Our ref: JB/2408
Your ref: H09-0442-25

25th March 2026

**RE: LAND OFF BATTLEFIELDS LANE SOUTH HOLBEACH SPALDING
PE12 7PG**

Drawing: Cycle Store

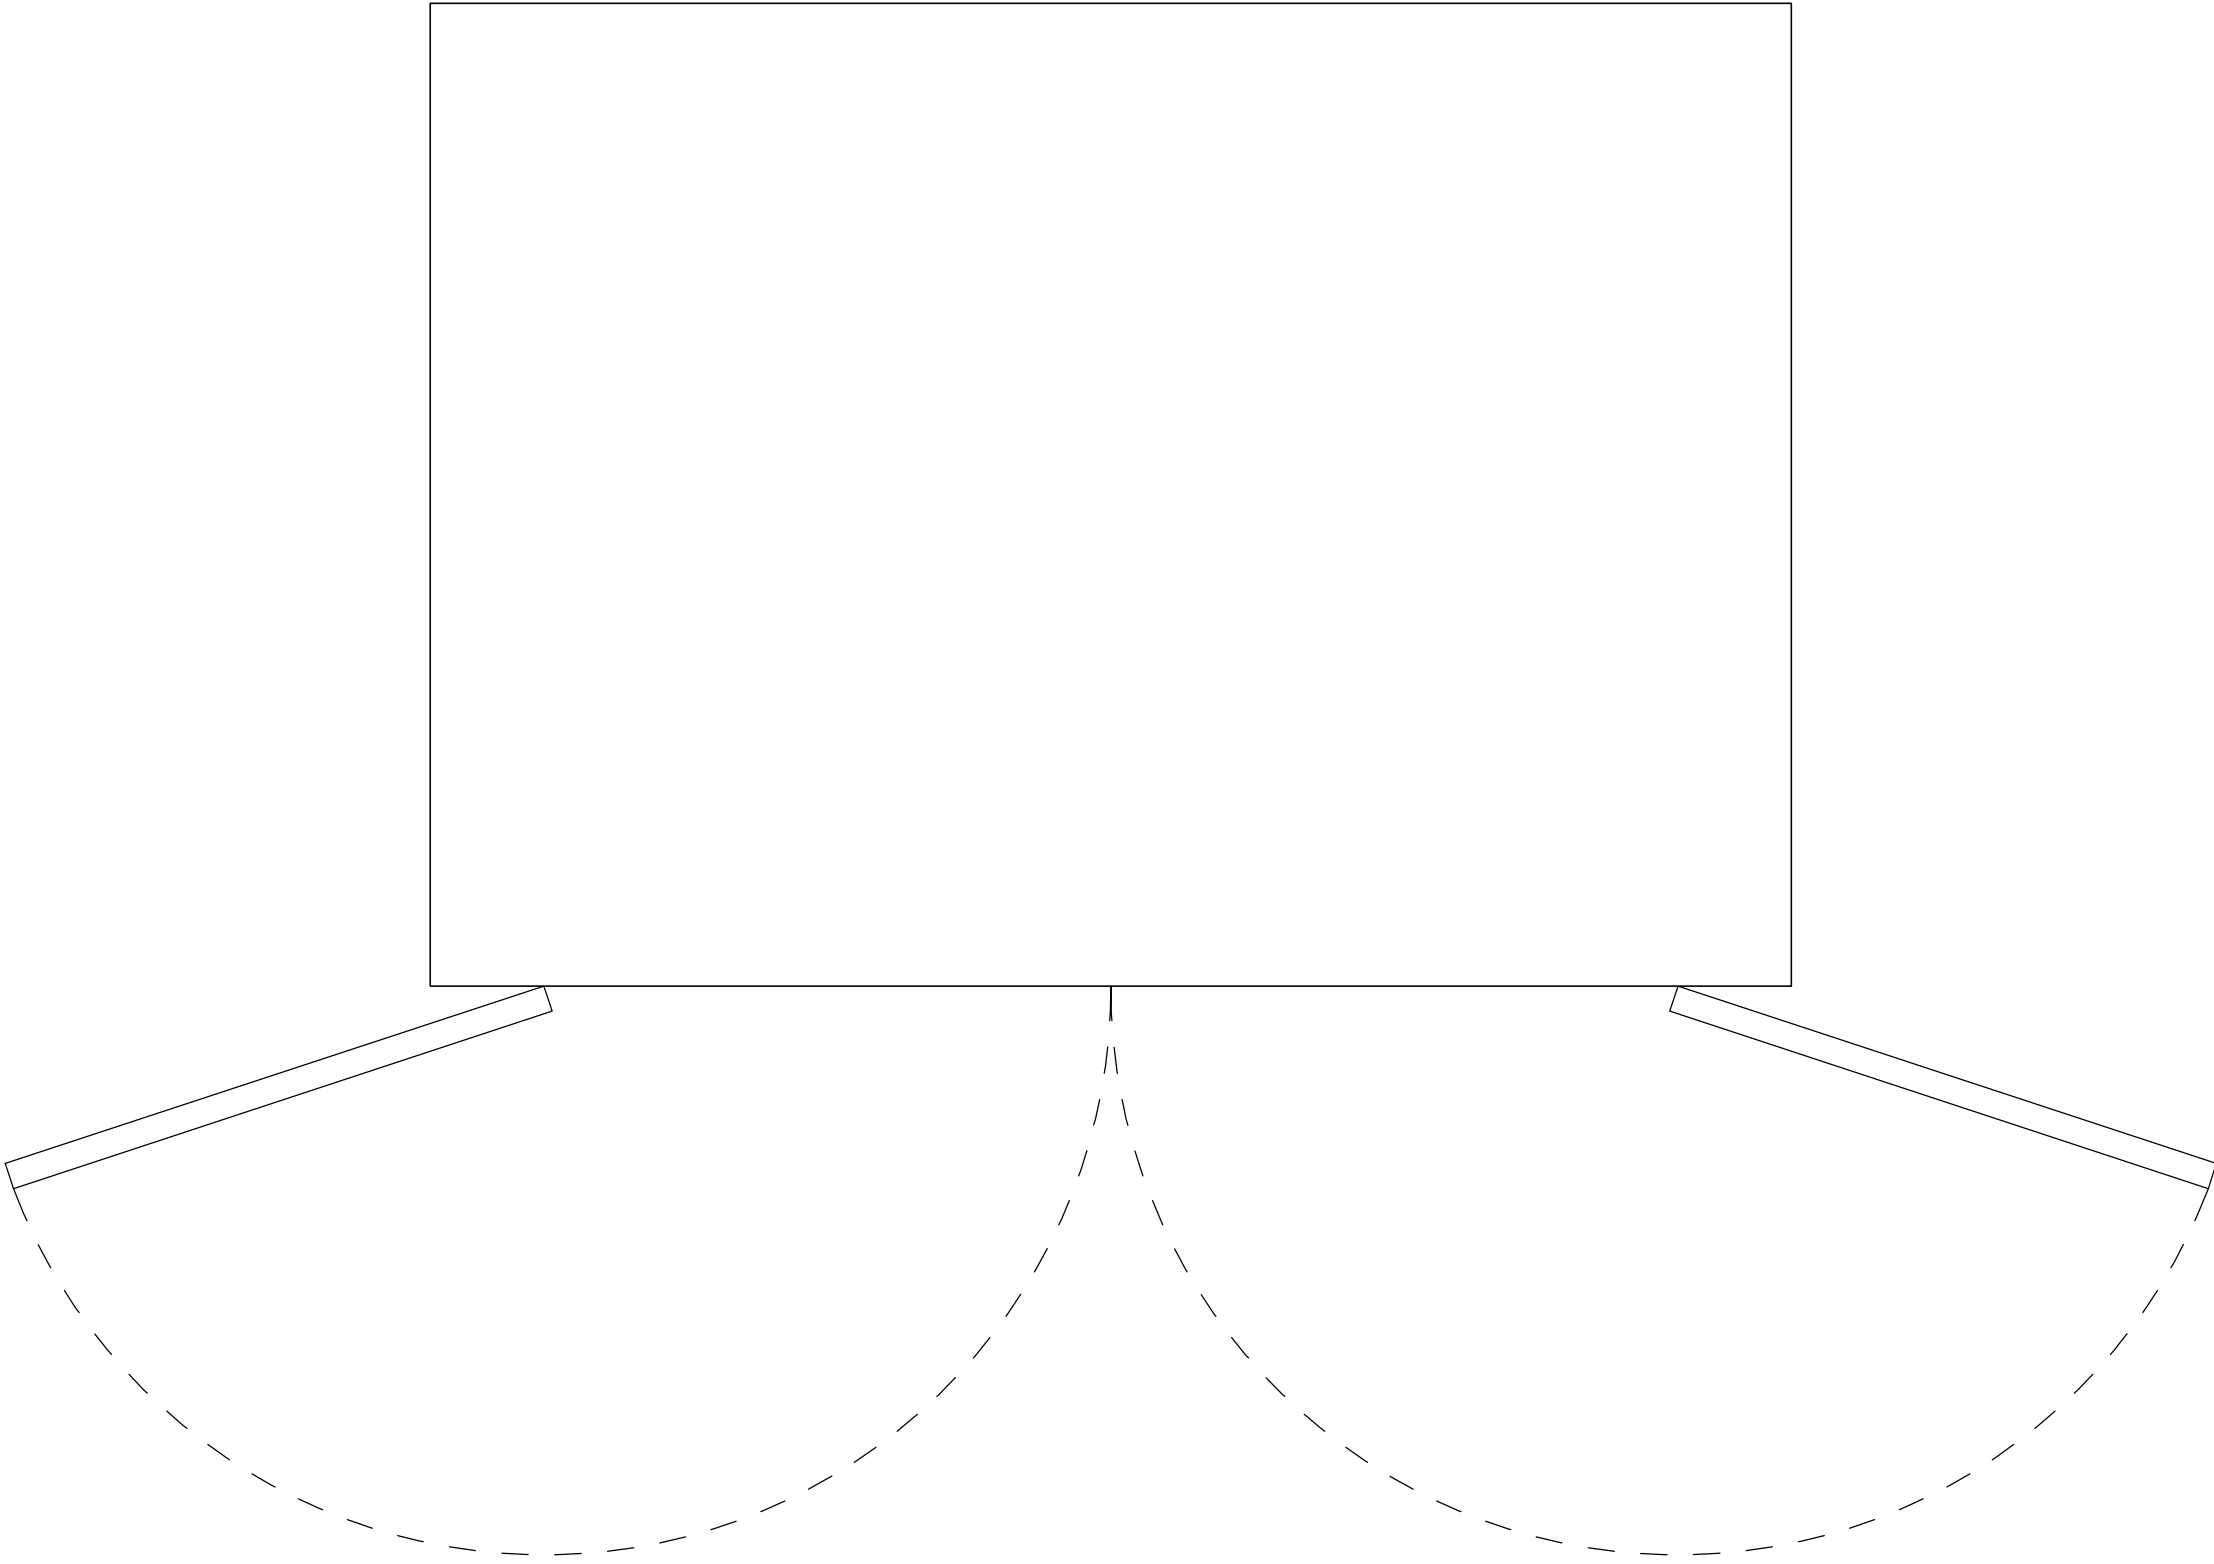
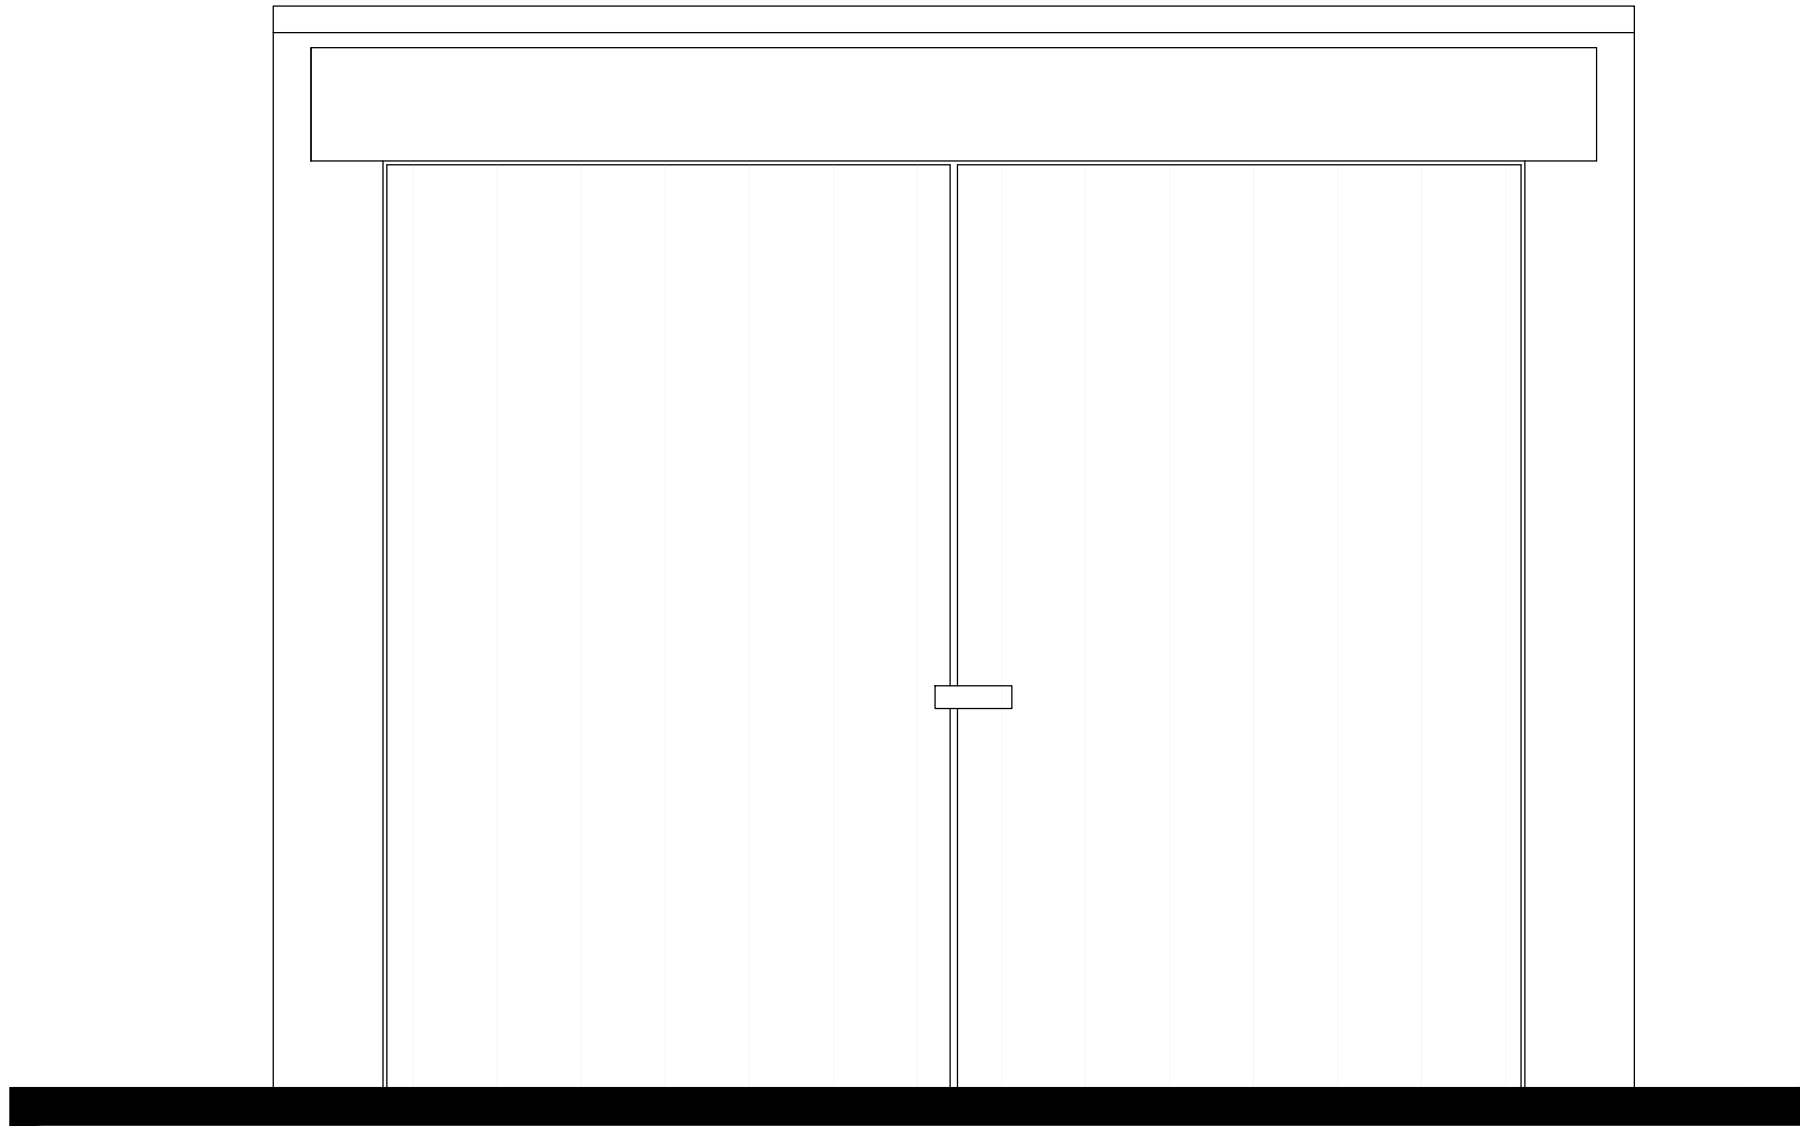
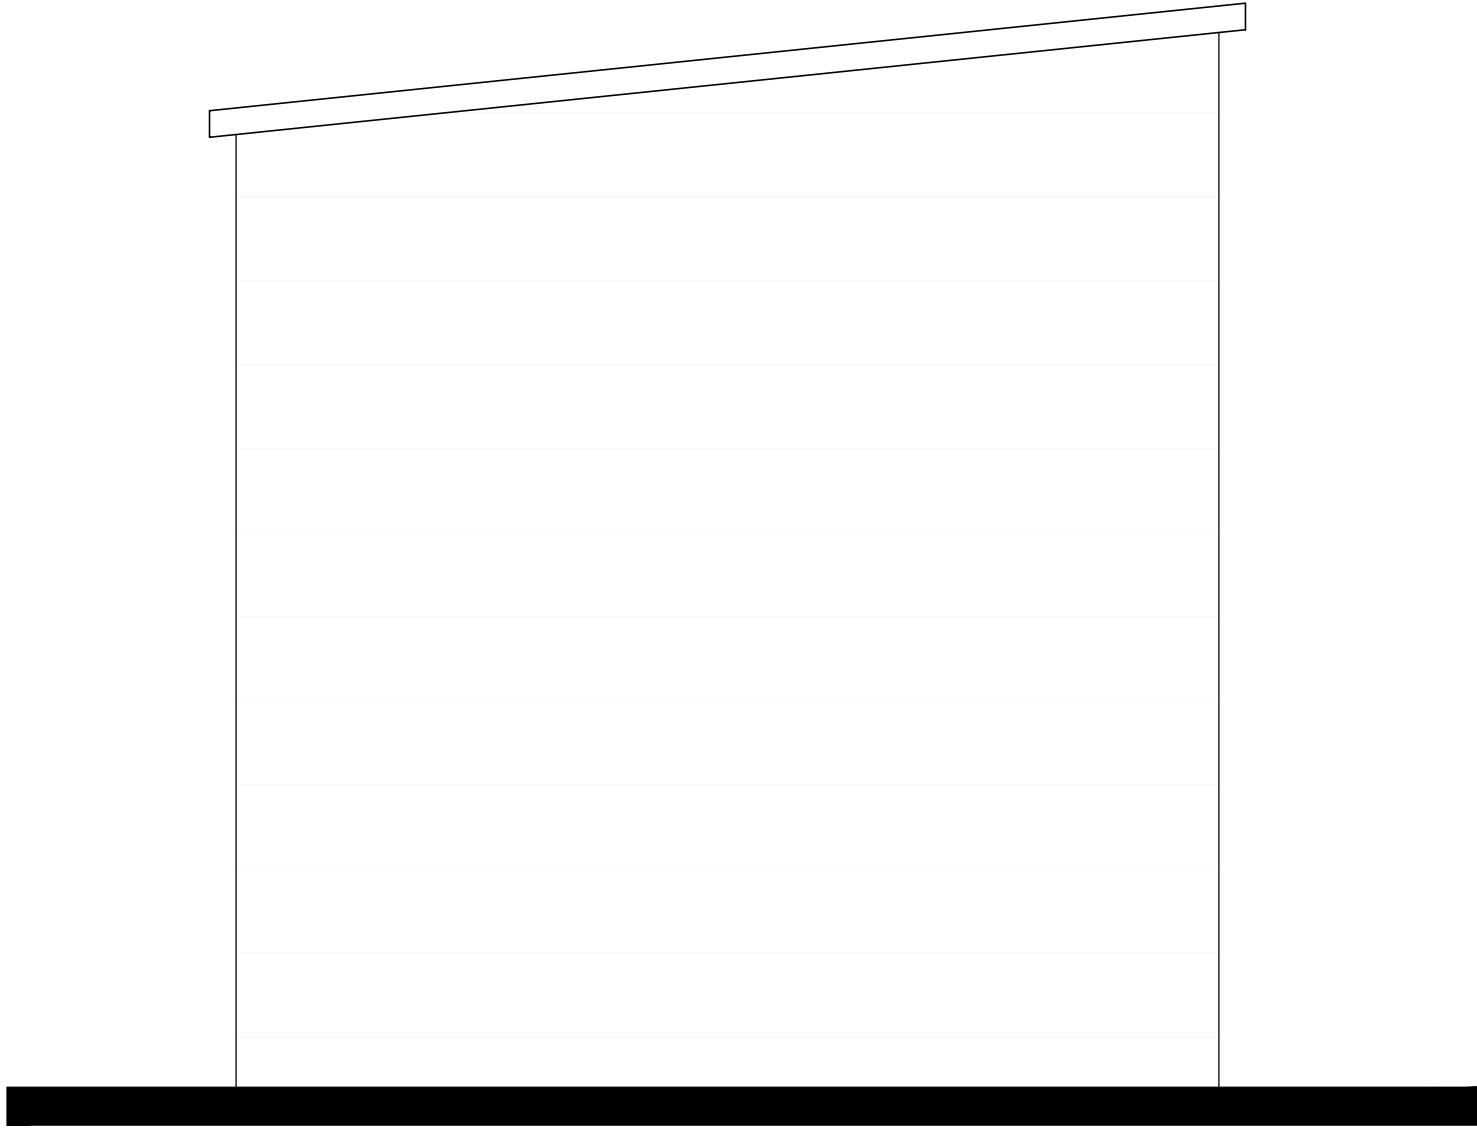
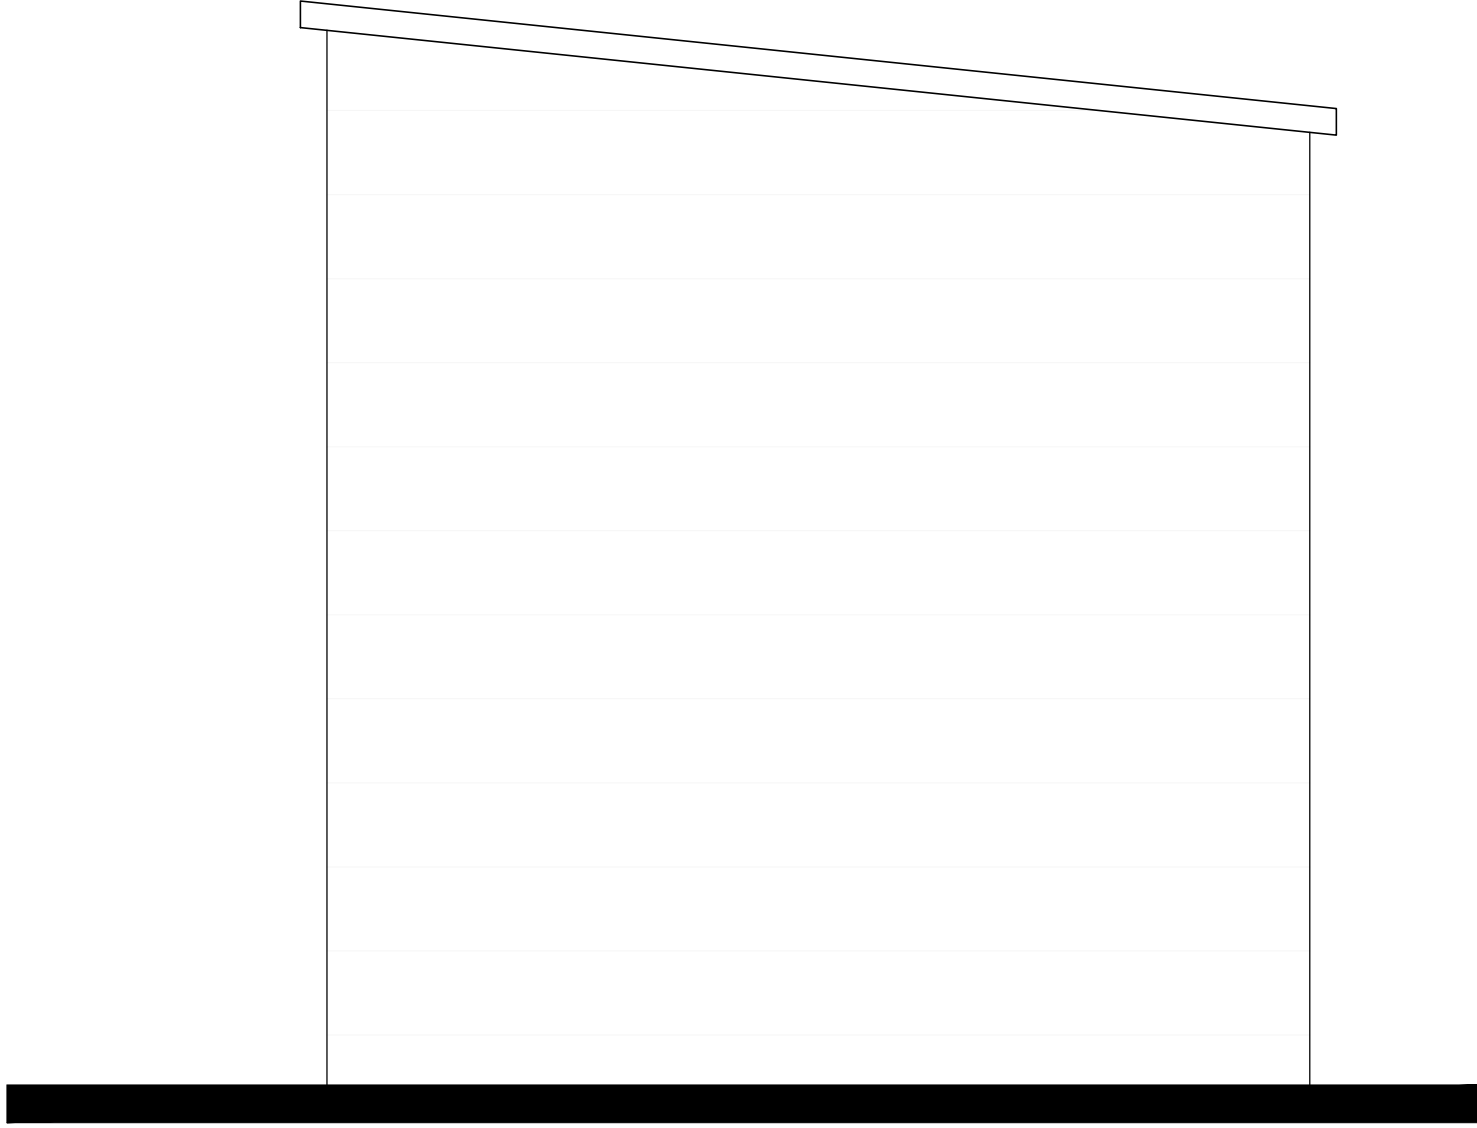
- Details of the buildings for cycle parking within the gardens.
 - I have asked the architect to provide details of these.
- Can you clarify how the link to Chaffinch Way is proposed to be delivered?
